East Park Energy

Environmental Statement

Appendix 4-3 EIA Scoping Opinion Response Matrix

September 2025

APFP Reference
Regulation 5(2)(a)

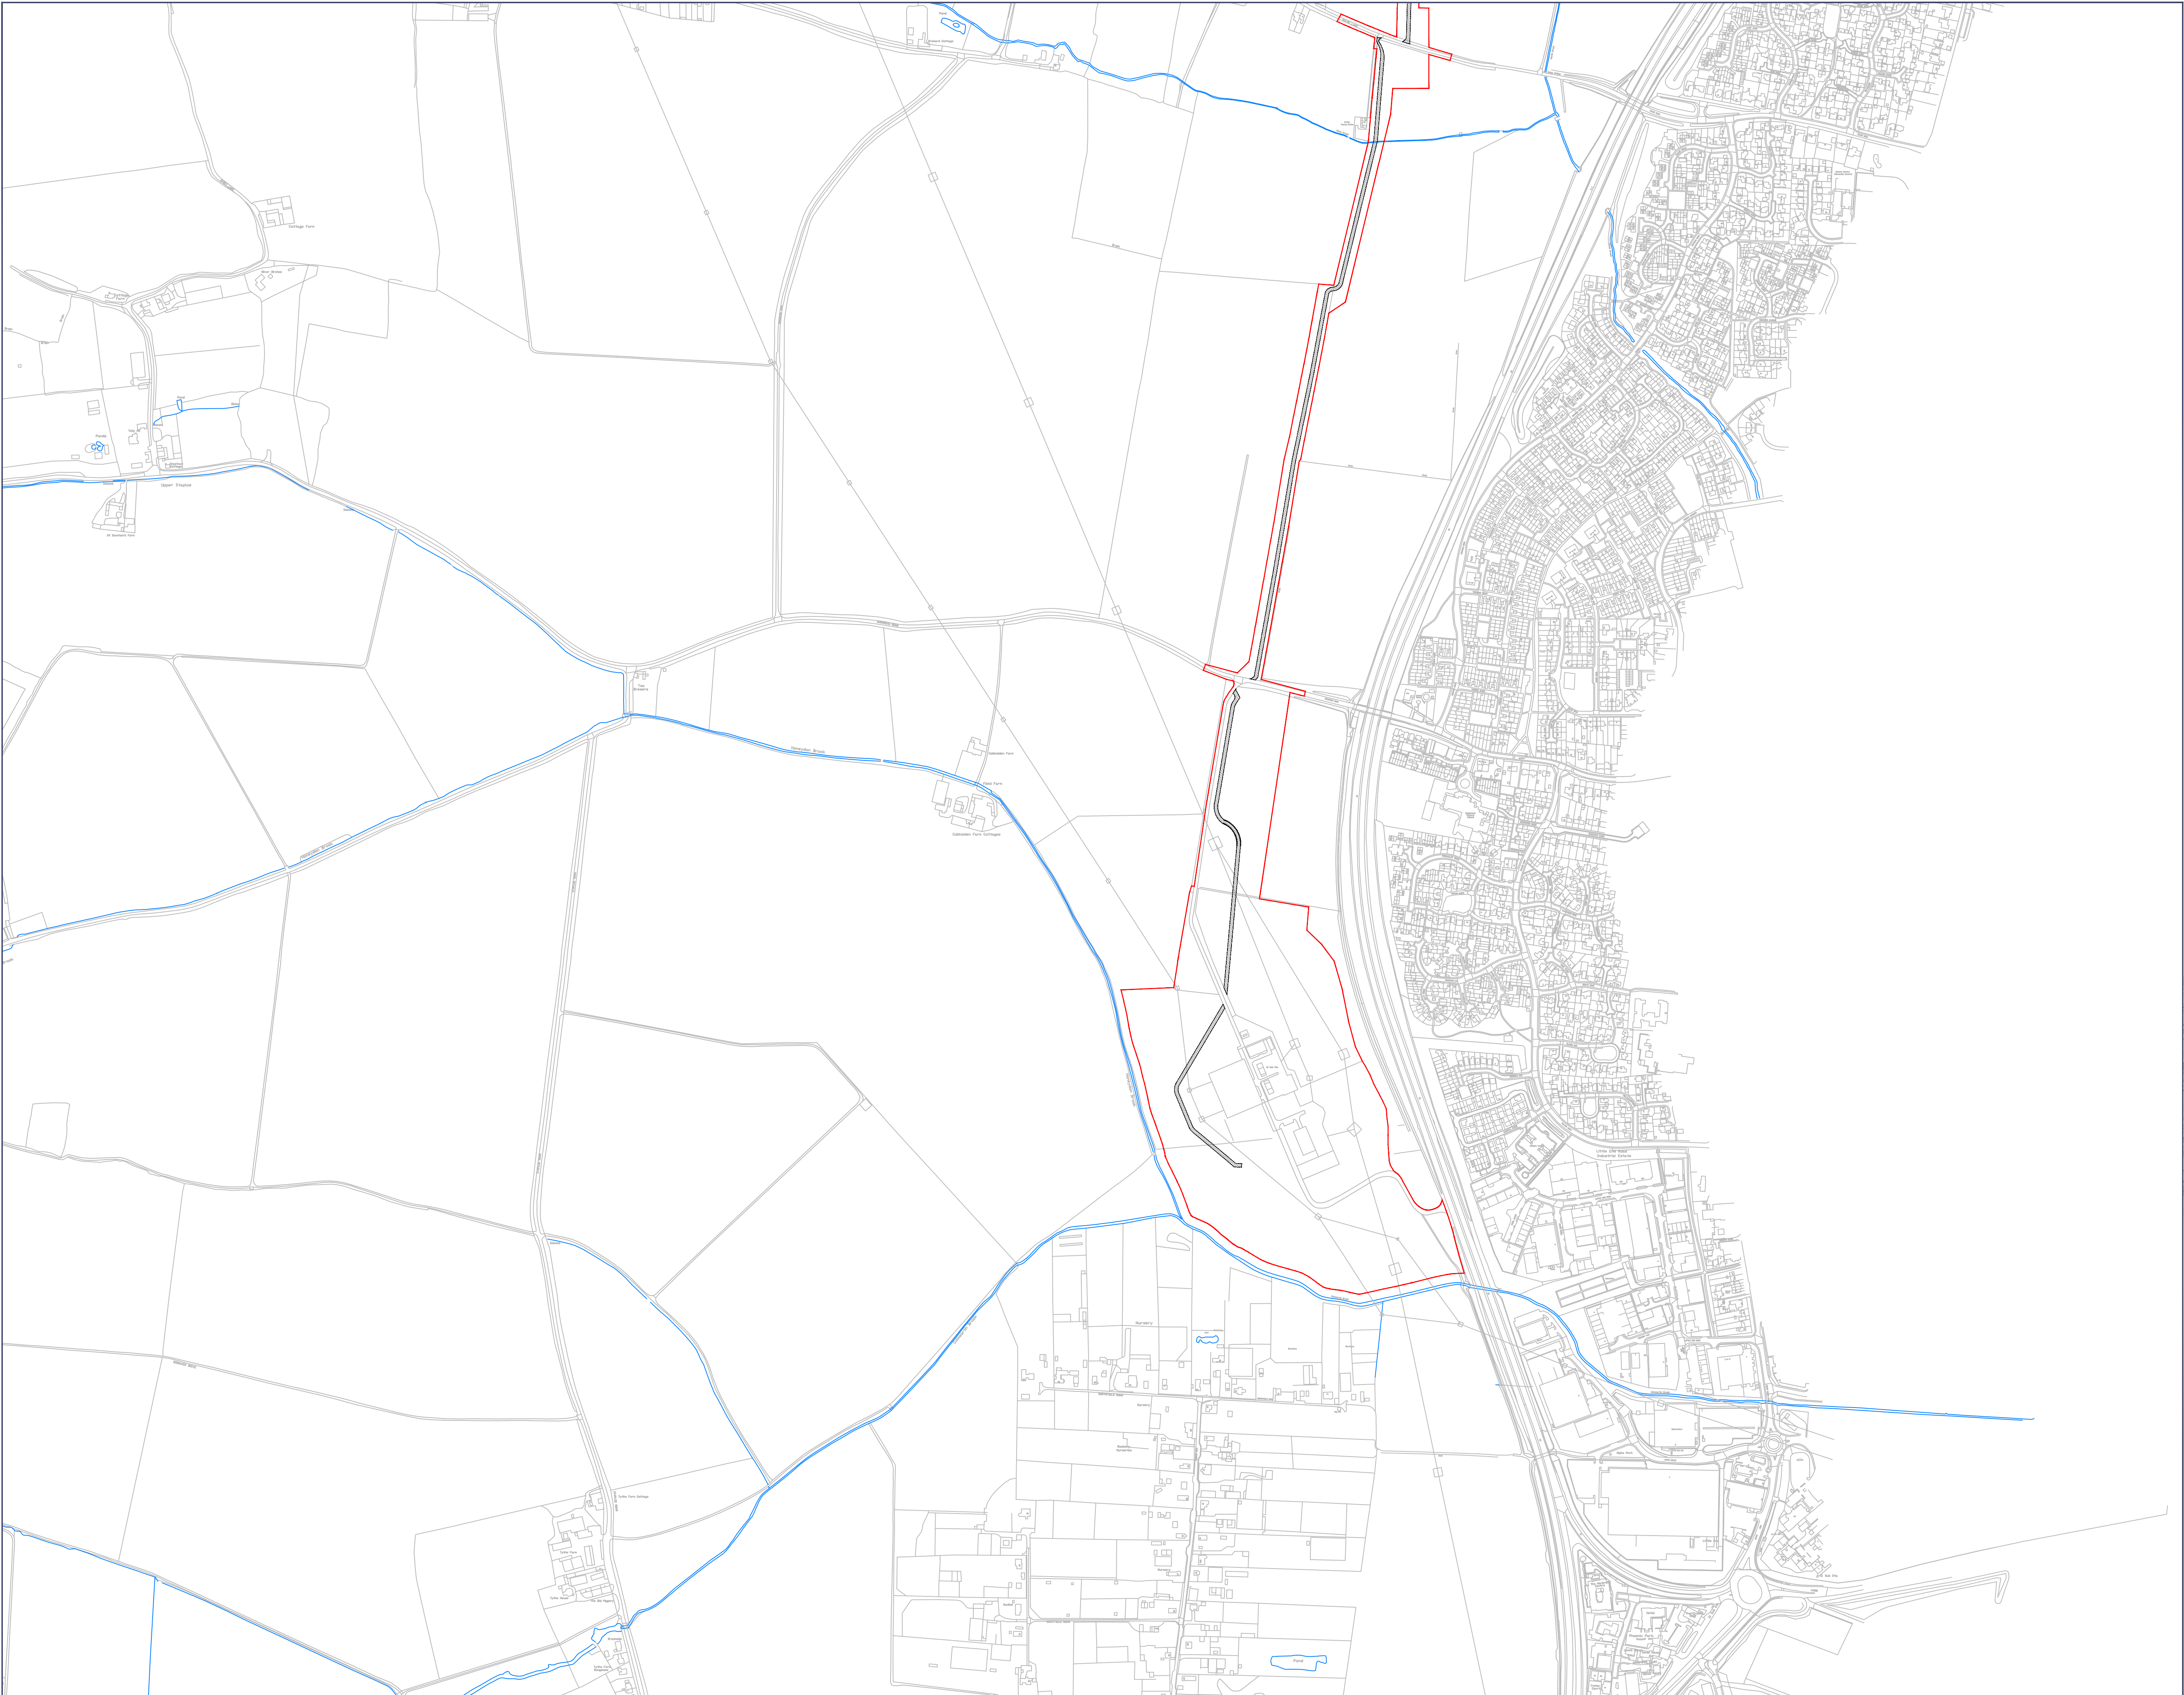
2.1.4	<p>Construction compounds</p> <p>The Scoping Report states that the Proposed Development would require one or more temporary construction compound(s) within the site, however, the exact location is yet to be determined. To ensure a robust assessment of likely significant effects (LSE), the ES should provide details regarding the number, location and dimensions of construction compounds.</p>	<p>The location of the temporary construction and decommissioning compounds are shown on ES Vol 3 Figure 2-5: Indicative Construction Access and Compounds, and secured by the limits of deviation of Work No. 7 as shown on the Works Plan [EN010141/DR/2.3].</p>
